Application Ref:	3/2026/0032				Ribble Valley Borough Council www.ribblevalley.gov.uk	
Date Inspected:	06/02/2026	Site Notice:	06/02/2026			
Officer:	MC					
DELEGATED ITEM FILE REPORT:					APPROVAL

Development Description:	Installation of non-illuminated fascia sign, non-illuminated hanging sign and 2 no. non-illuminated window poster signs
Site Address/Location:	19 - 21 Berry Lane Longridge PR3 3JA

Elevations - Signage
Proposed

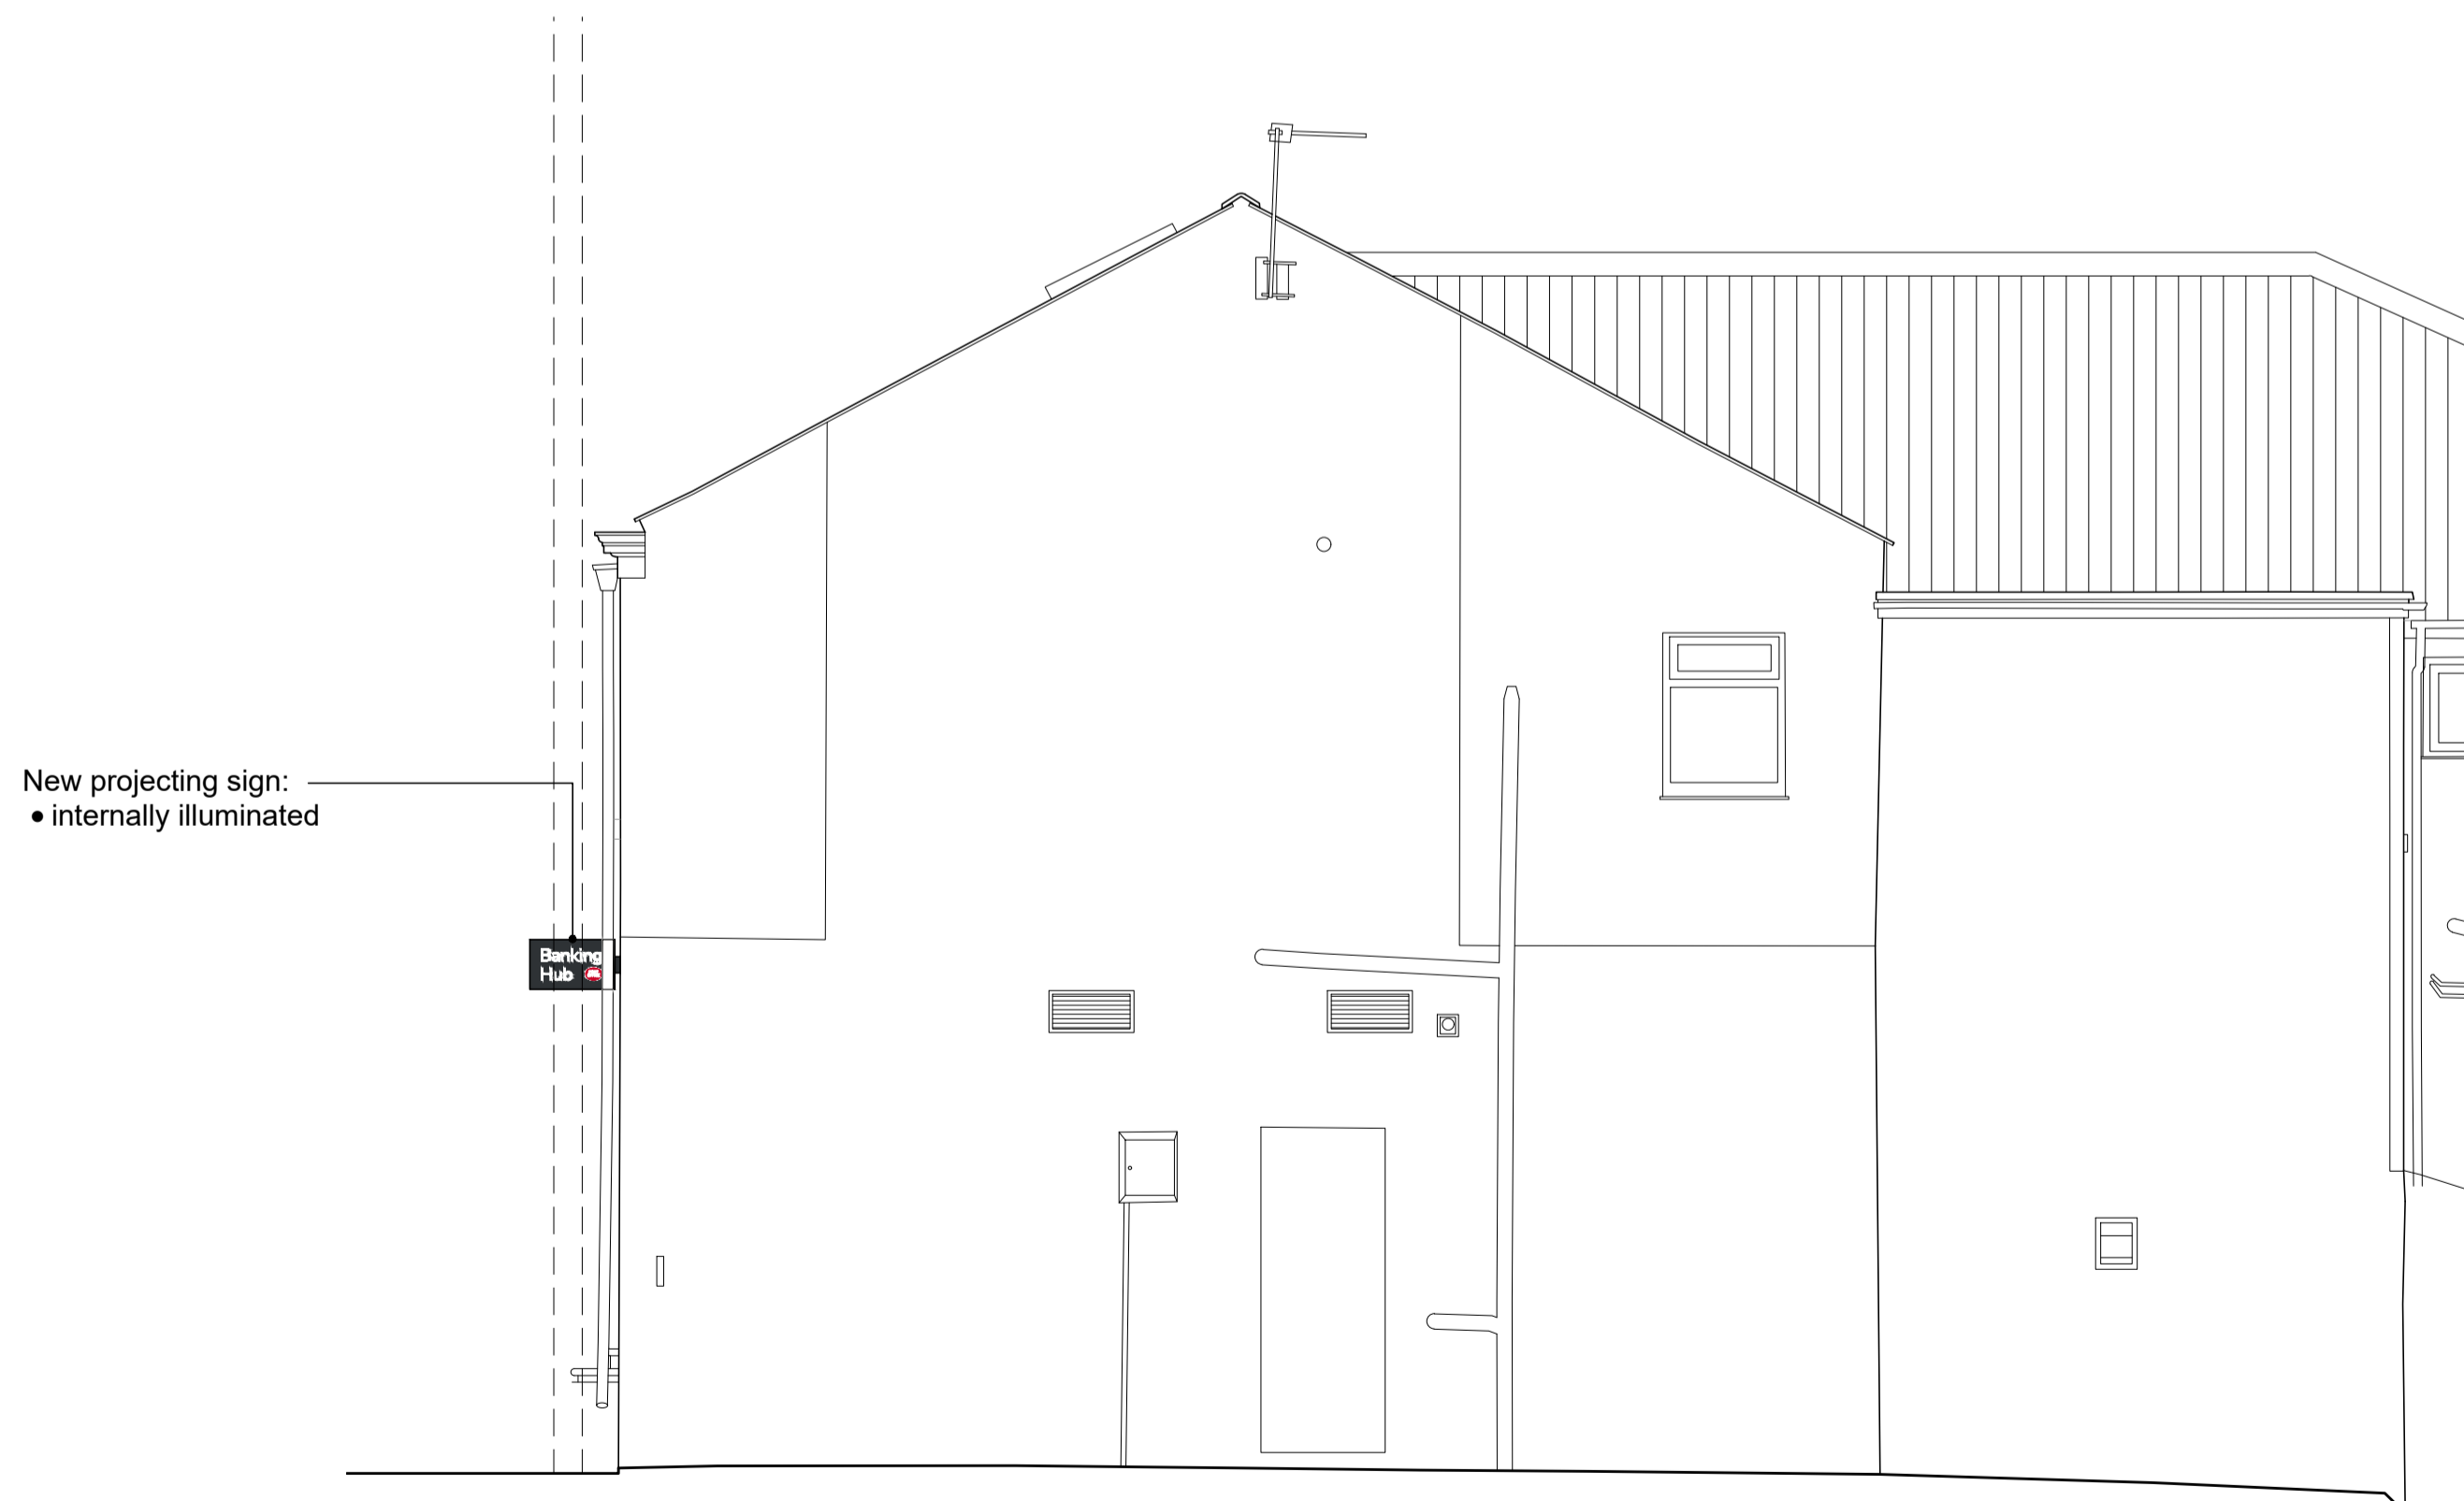
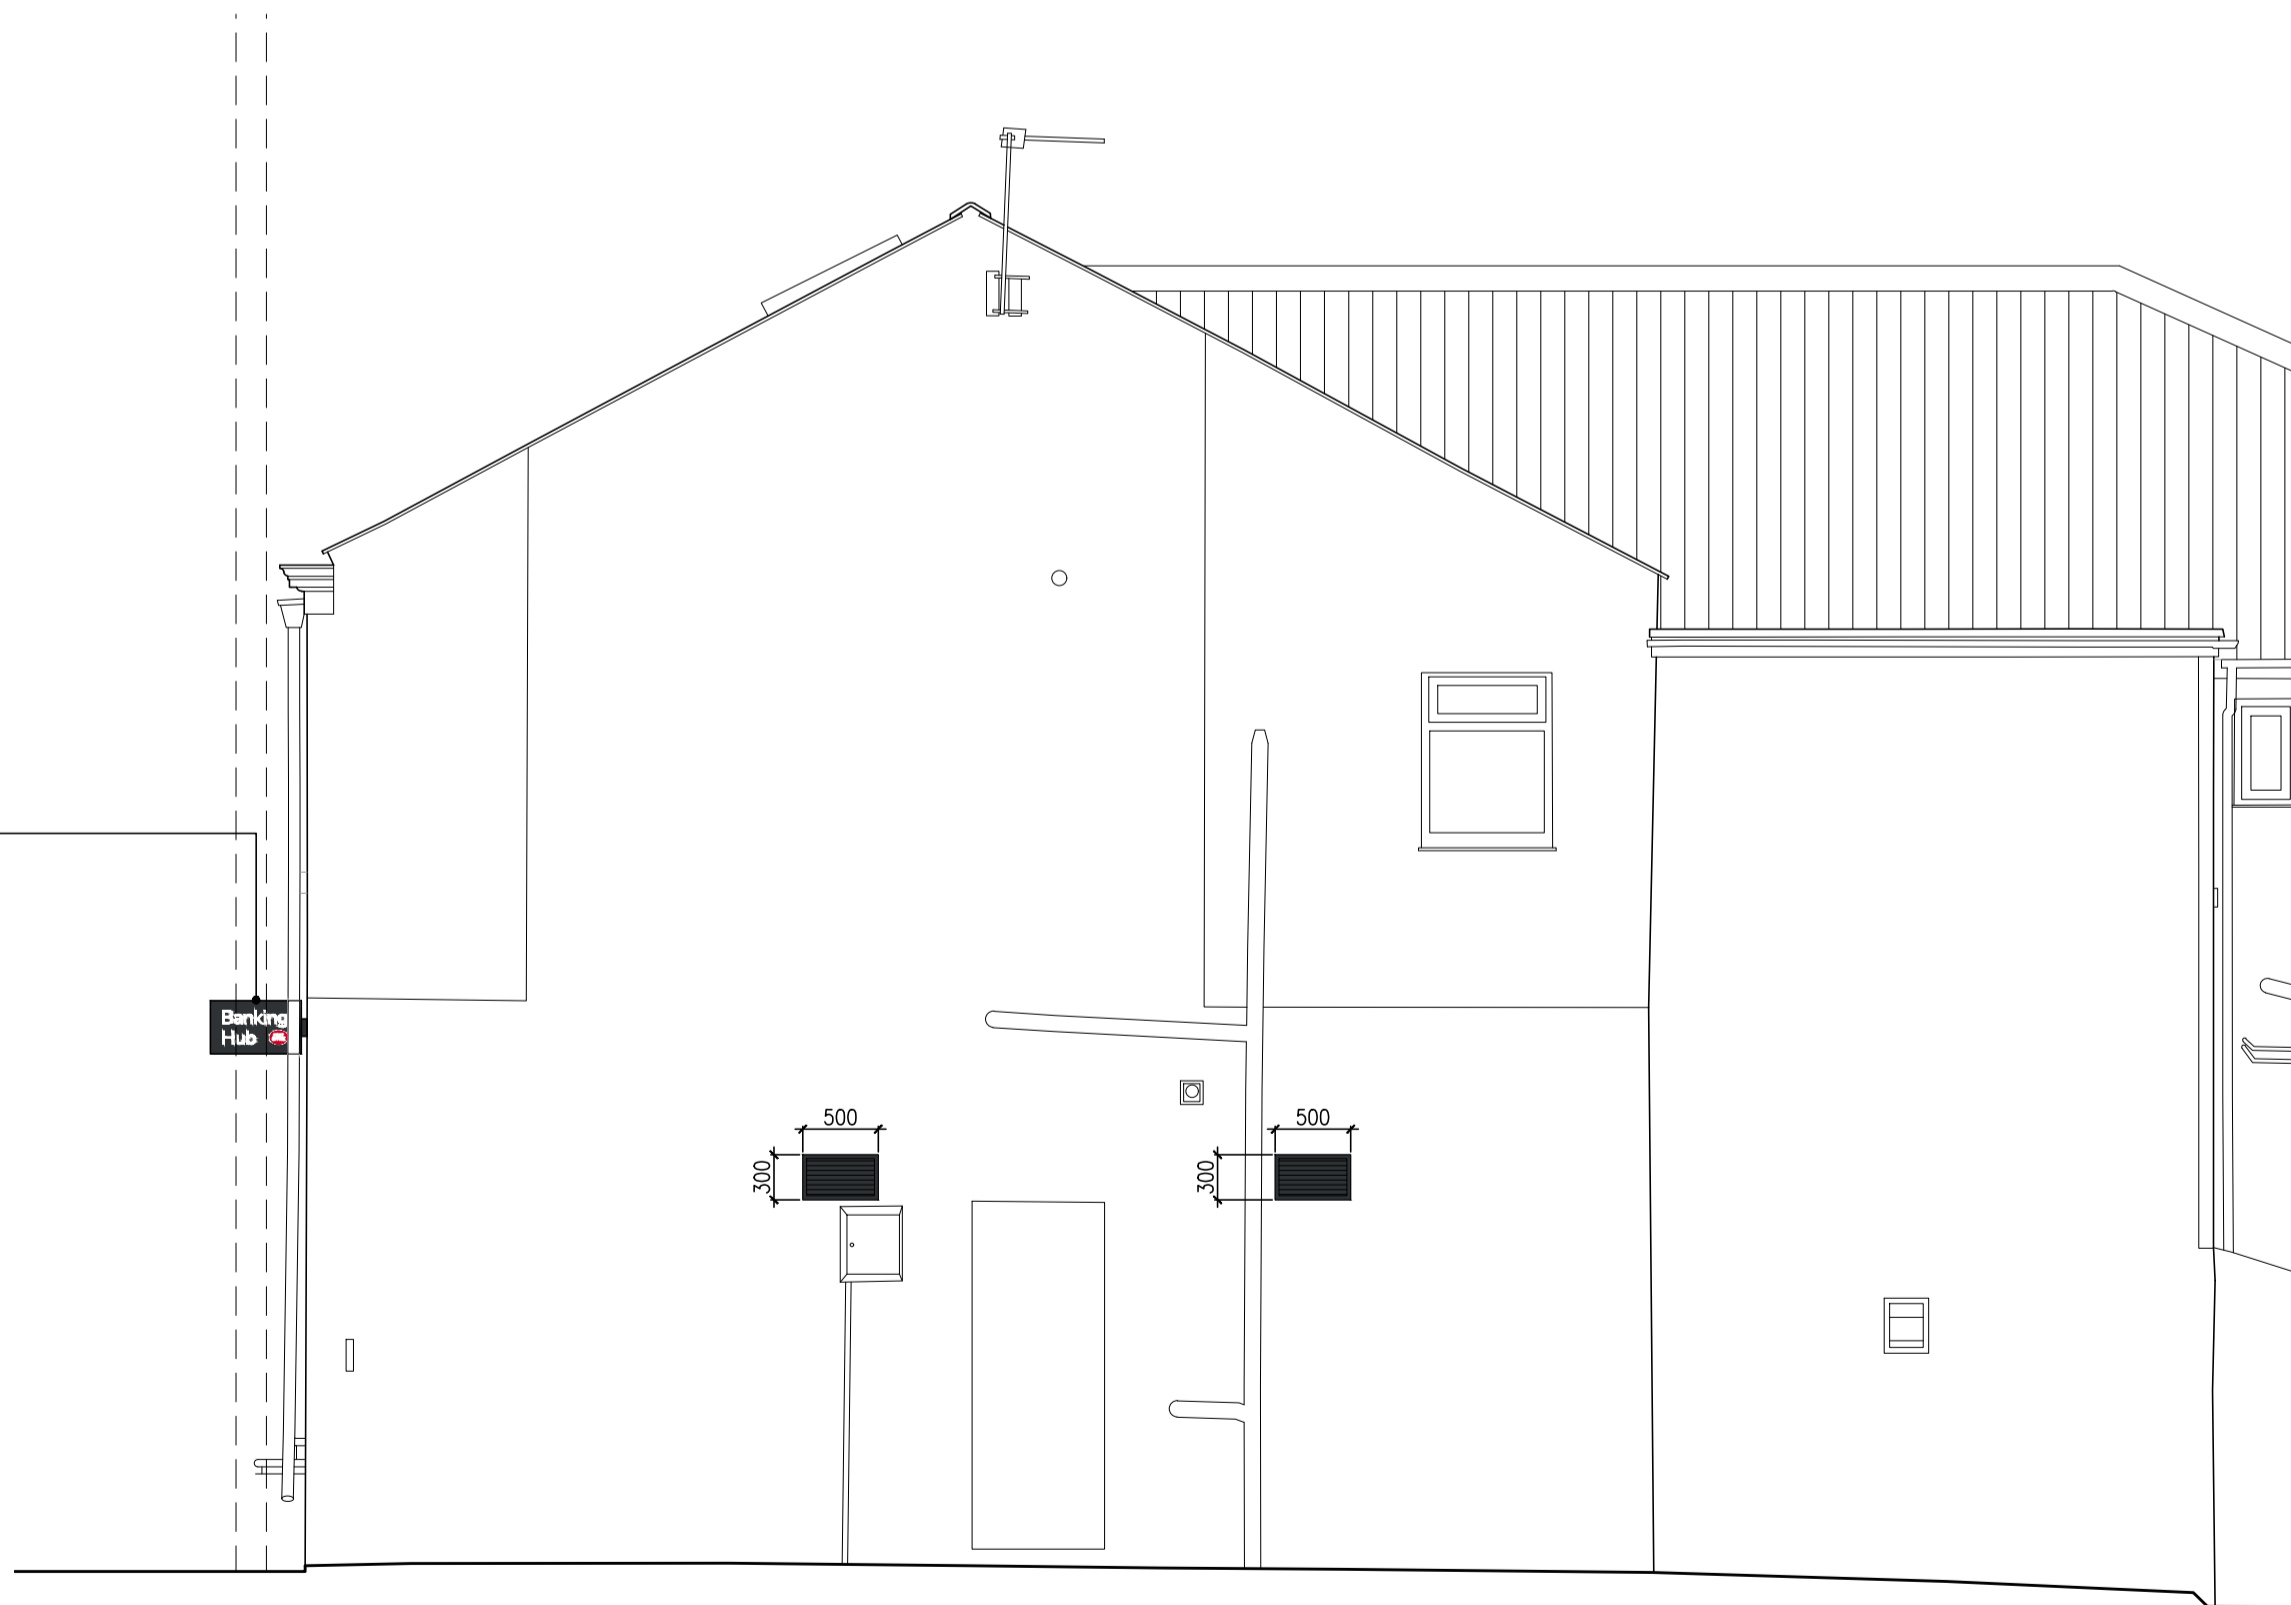
CONSULTATIONS:	Parish/Town Council
Longridge Town Council supports the principle but objects to the proposed illumination which would not be sympathetic to the historic streetscape. The illumination would result in harm to the Longridge Conservation Area and conflicts with the Ribble Valley Core Strategy.

CONSULTATIONS:	Highways/Water Authority/Other Bodies
LCC Highways:	No objection to conditions restricting the level of illumination and screening the light sources.

The proposed signage is considered to be acceptable in terms of its size, siting and external materials of construction. The signage would no longer be illuminated which is considered to be more appropriate within the Longridge Conservation Area and the signage would be similar in terms of size, scale and colour to other advertisements within the vicinity of the site.

Whilst the application has been assessed by LCC Highways with regard to the illumination and candela level, no objection has been raised. Given that the scheme has now been amended to non-illuminated signage, no conditions are considered necessary in relation to illumination.
